Your Ref: BE/1/08/ *YVW* Our Ref: PH/PL/ARU/08/05 Date: 12 February 2008
 Contact Name: Peter Hardy Tel: 0845-60-70-999 ext: 40113 Direct Dial No: 01273 404868

Re: Land at Oldlands Farm, Shripney Road, Bognor Regis

Peter Hardy
Crime Prevention Design Adviser

Title: Provisional Masterplan

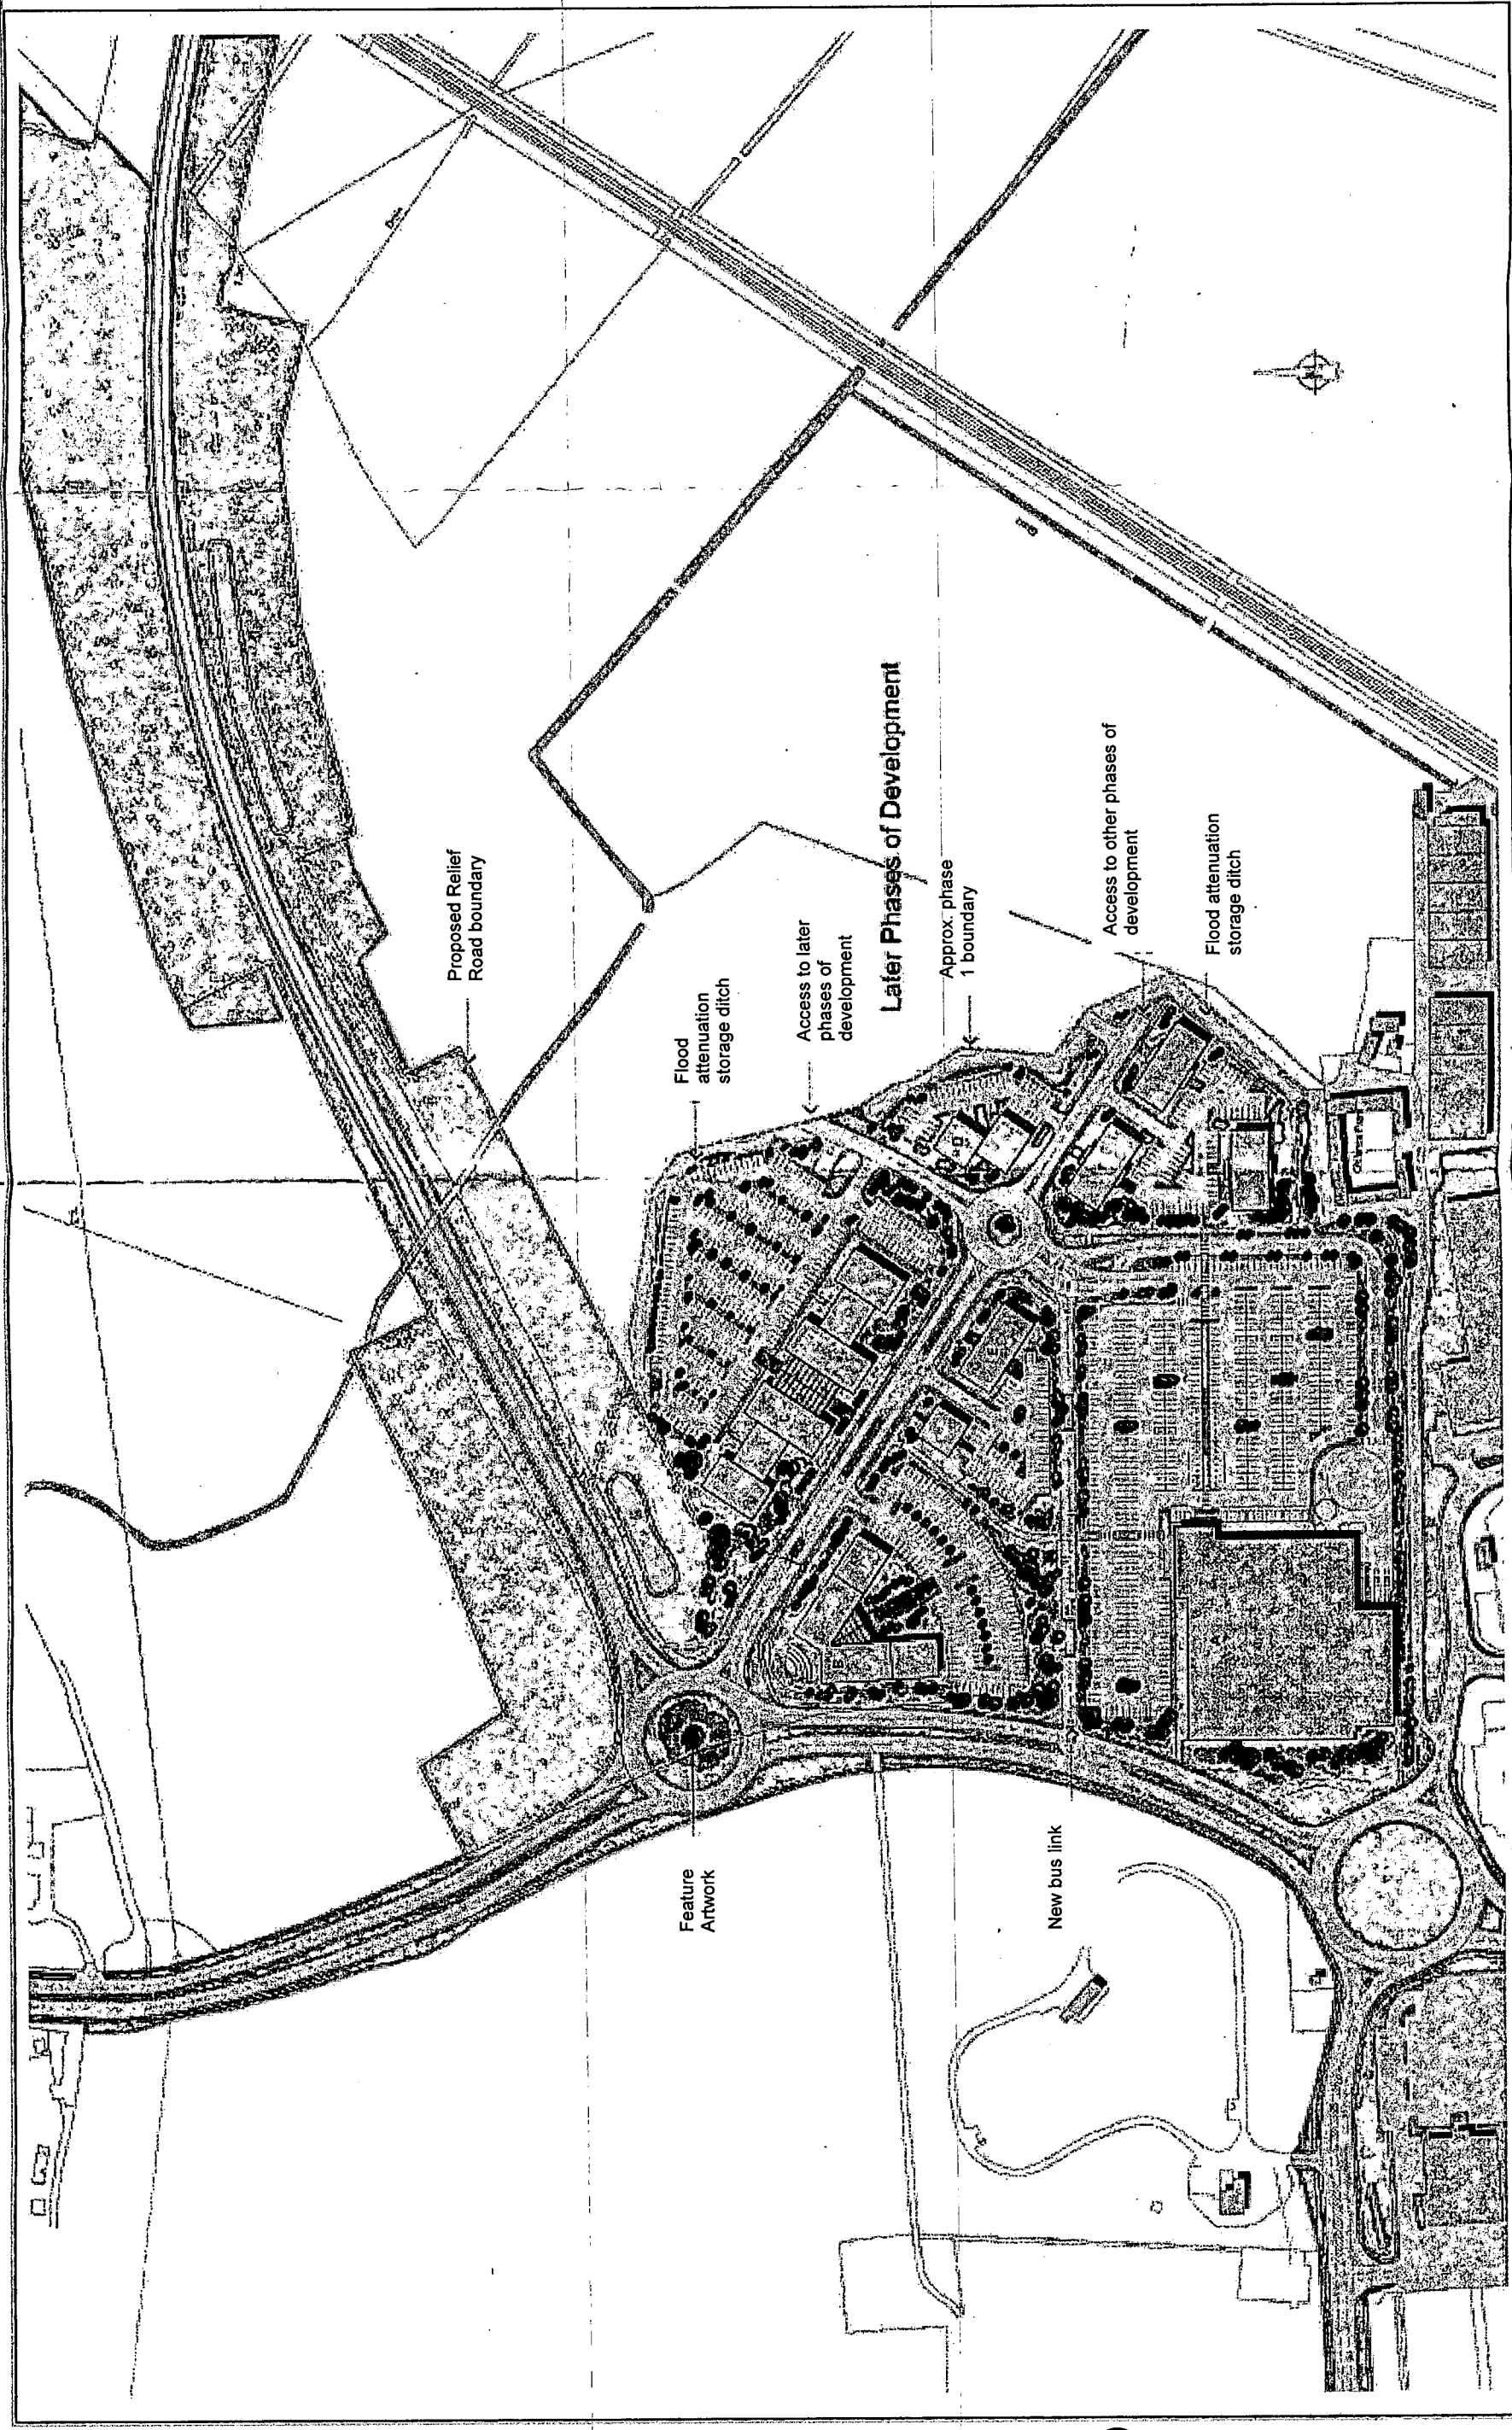
Secondly, the layout proposed in this layout is very permeable for vehicles and pedestrians. There are few, if any, secure boundaries/car parks proposed and this means that the building fabric becomes the first line of defence.

Crime prevention measures should be taken at the earliest opportunity and I would therefore be looking for less permeability and more security to perimeters. We have to remember that at night this proposal would be irresistible to "boy racers" and other youngsters. At present, they would be able to go wherever they like unchallenged.

The numerous pedestrian routes all directed towards reaching the supermarket, should at best be gated, to deter trespass. Some of these routes may be unnecessary and could easily be omitted. This would restore "defensible space" and enable users to control their own environment.

If the supermarket were to be open 24/7, then this would reduce opportunities for crime and disorder at their premises. It may be that there will be monitored CCTV/24 hour guarding, which would ease my concerns.

Finally, lighting will be an important consideration, both around the blocks and in the car parks.
